Appeal Decision

Appeal Ref: APP/T2350/D/17/3192227

13 Glen Avenue, Ribchester PR3 2ZQ

- The appeal is made under section 78 of the Town and Country Planning Act 1990 against a refusal to grant planning permission.
 - The appeal is made by Mr & Mrs T & A Baker against the decision of Ribble Valley Borough Council.
 - The application Ref 3/2017/0741, dated 6 August 2017, was refused by notice dated 4 October 2017.
 - The development proposed is a "*single storey conservatory extension to side*".
-

PROPOSED PLANS AND ELEVATIONS
 Drg No 2 31-07-2017

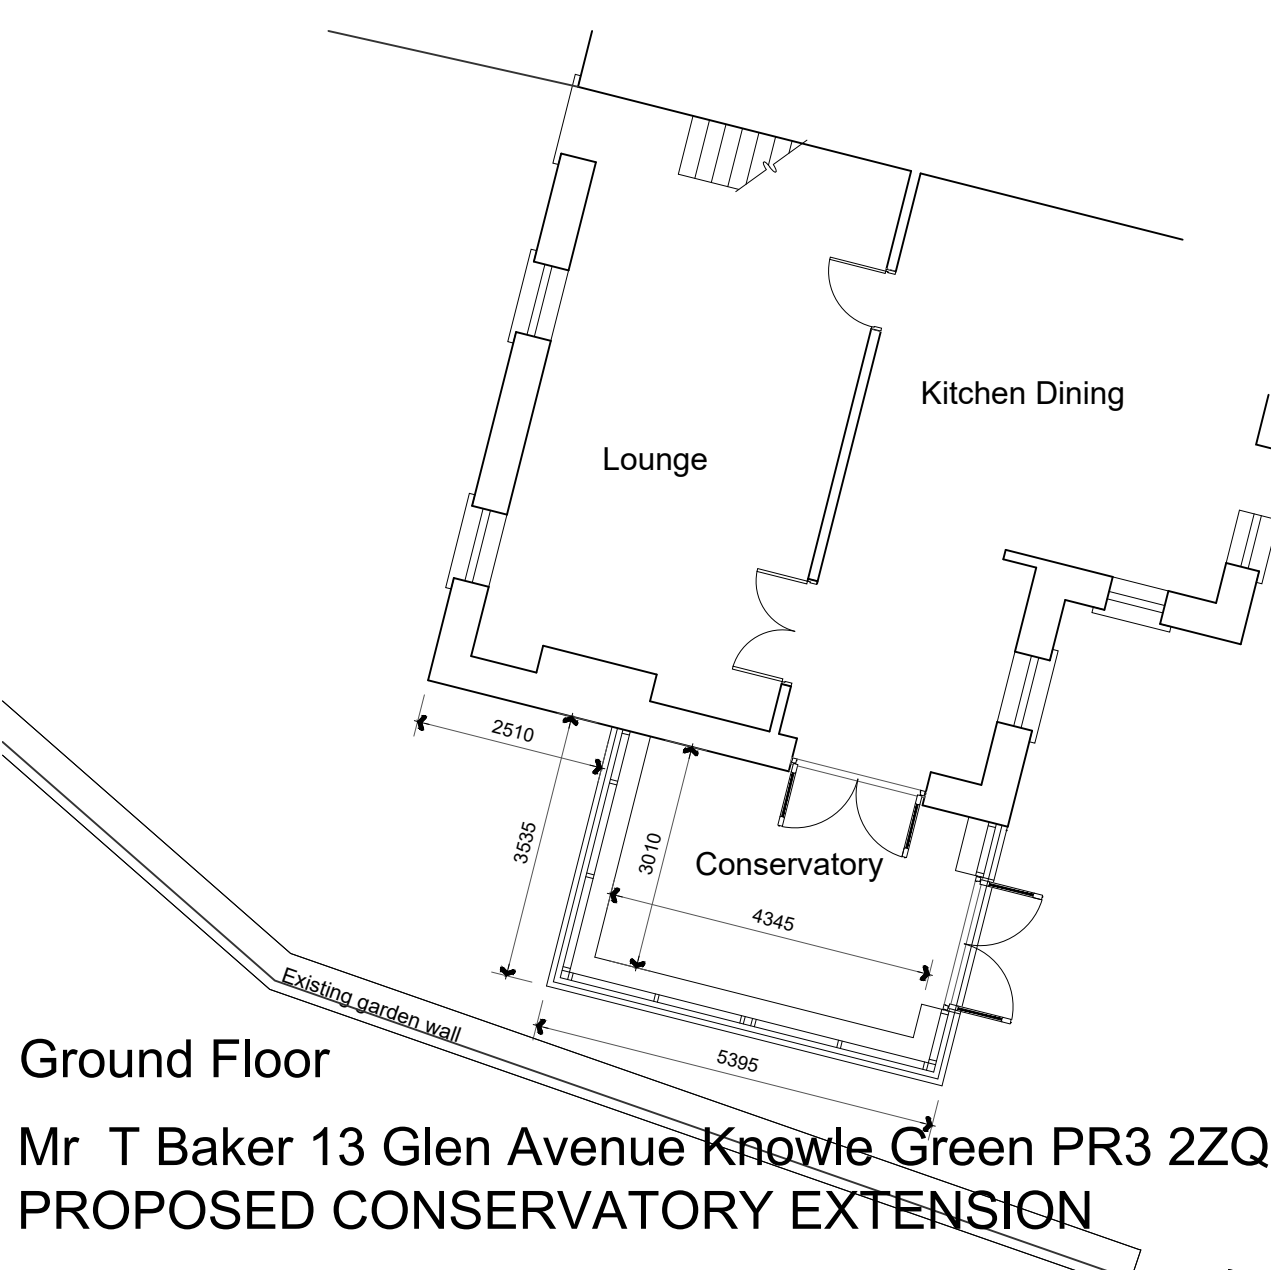
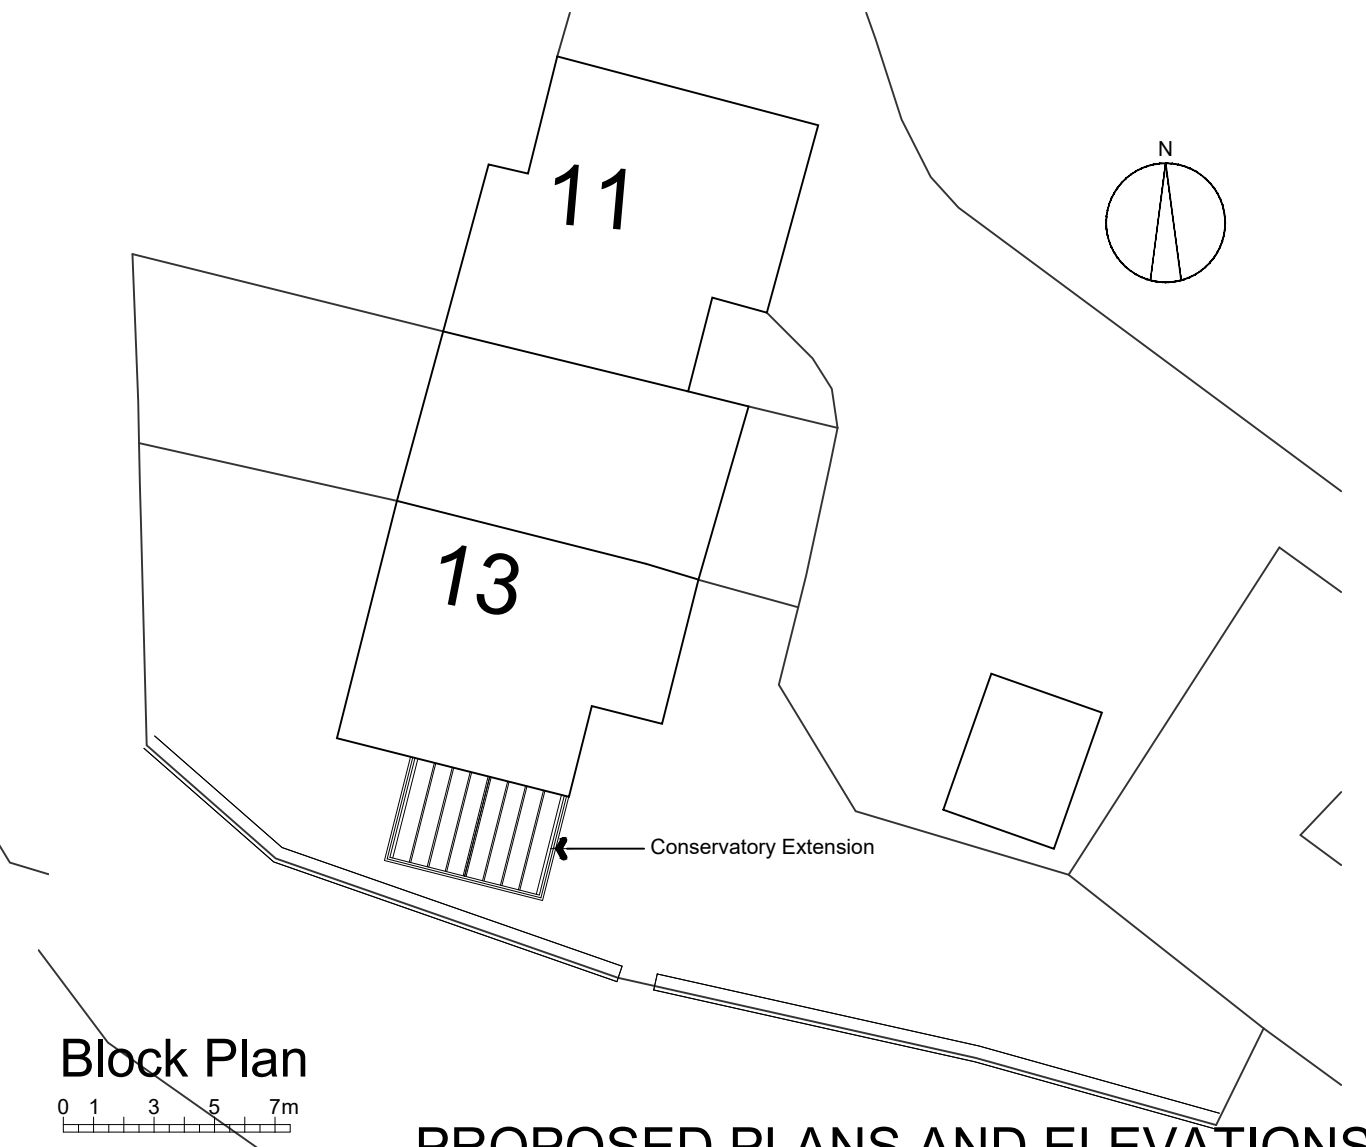
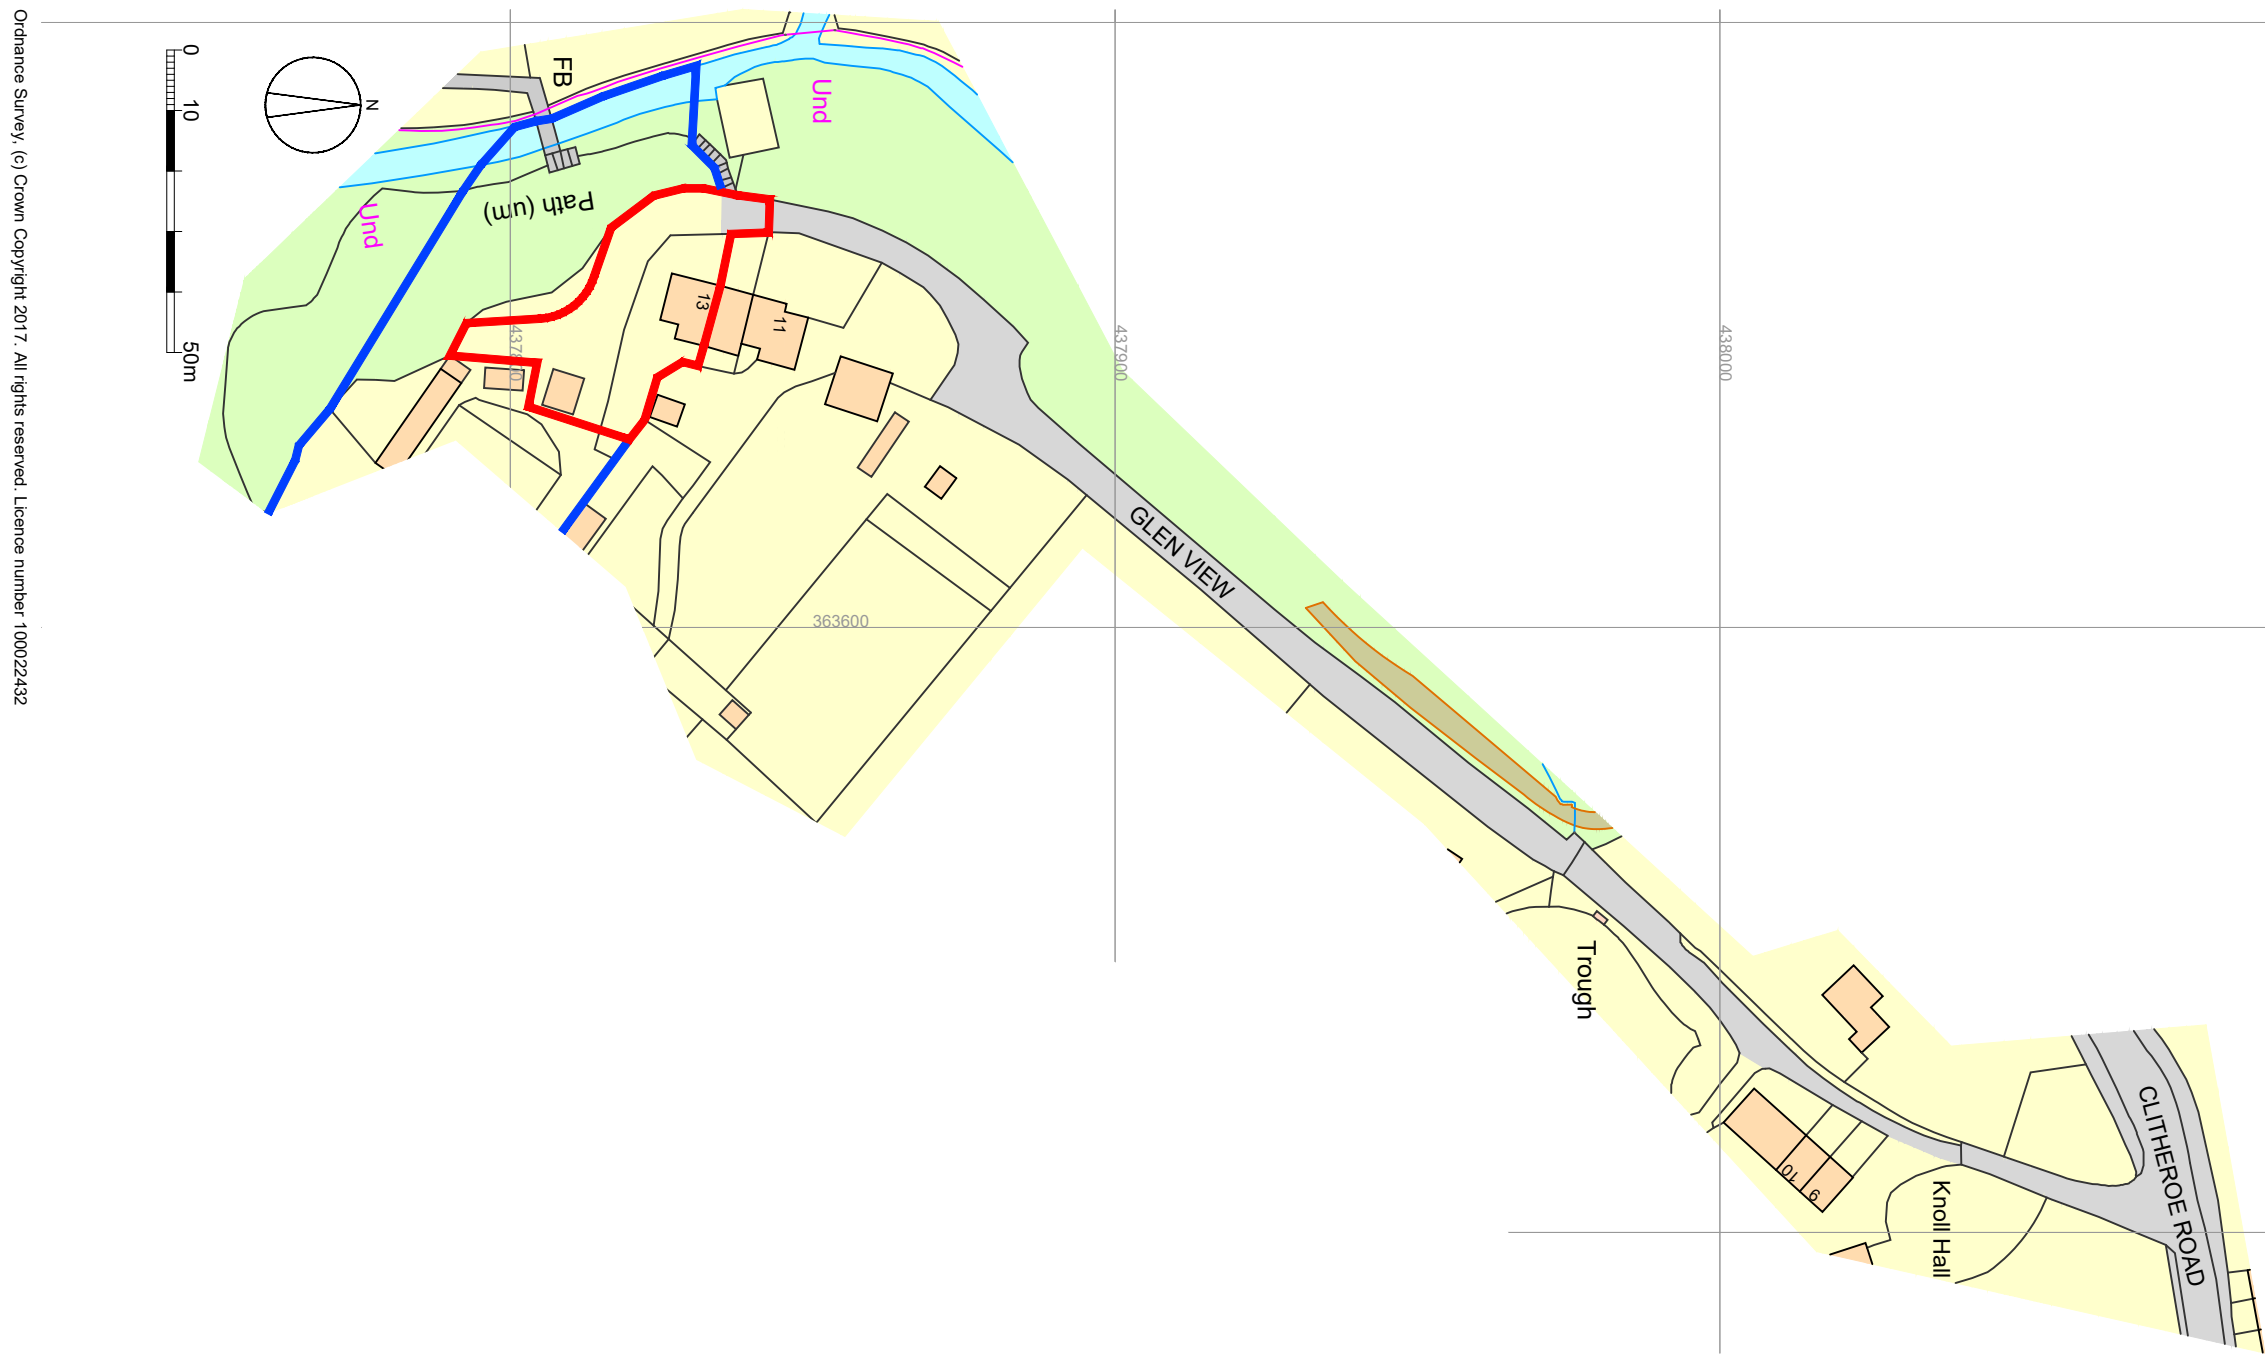
6. Having regard to the above, the addition of a single storey side extension consisting of a wood effect frame with considerable glazing to its walls and roof

would introduce an overtly modern addition to the property and the end of the terraced row. When viewed from some vantage points on the public footpath, the side extension would be a prominent and dominant feature adjoining an existing first floor window with an incompatible and incongruous design that would harmfully detract from the traditional character and appearance of the end terraced property. I, therefore, consider that the single storey side extension as proposed would significantly harm the character of the host property and the area in a countryside location.

9. I conclude that the proposed development would significantly harm the character and appearance of the host building and the area. The proposal, therefore, conflicts with Policies DMG1 and DMH5 of the Ribble Valley Core Strategy 2008 - 2028 - A Local Plan for Ribble Valley, adopted December 2014. When taken together, the policies, amongst other things, seek that all new development must be of a high standard of building design and be sympathetic in terms of scale, massing, style, features and building materials. The policies are consistent with the design objectives of the National Planning Policy Framework and its intention that the intrinsic character and beauty of the countryside is recognised.
